Application for a Non-Material Amendment Following a Grant of Planning Permission

Proposed part two storey and part single storey side extension

22/00973/FULL

render only above dpc rather than brick and render

Title
Proposed Elevations

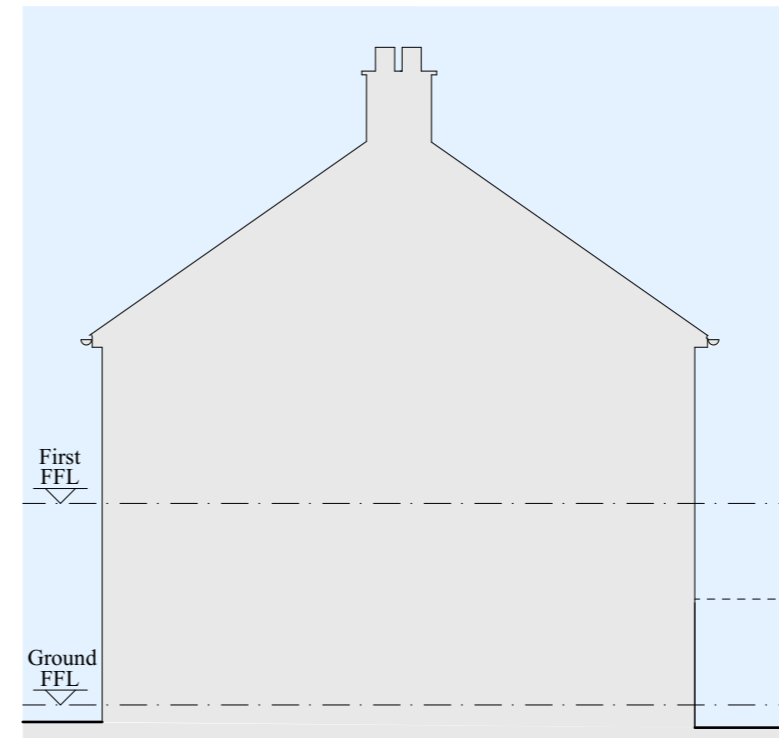
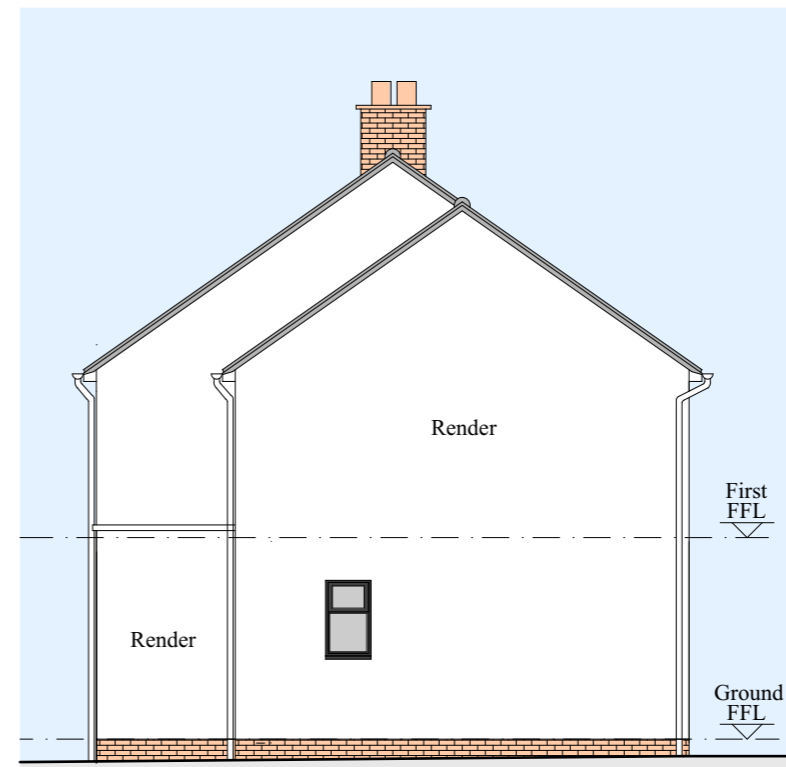
client change
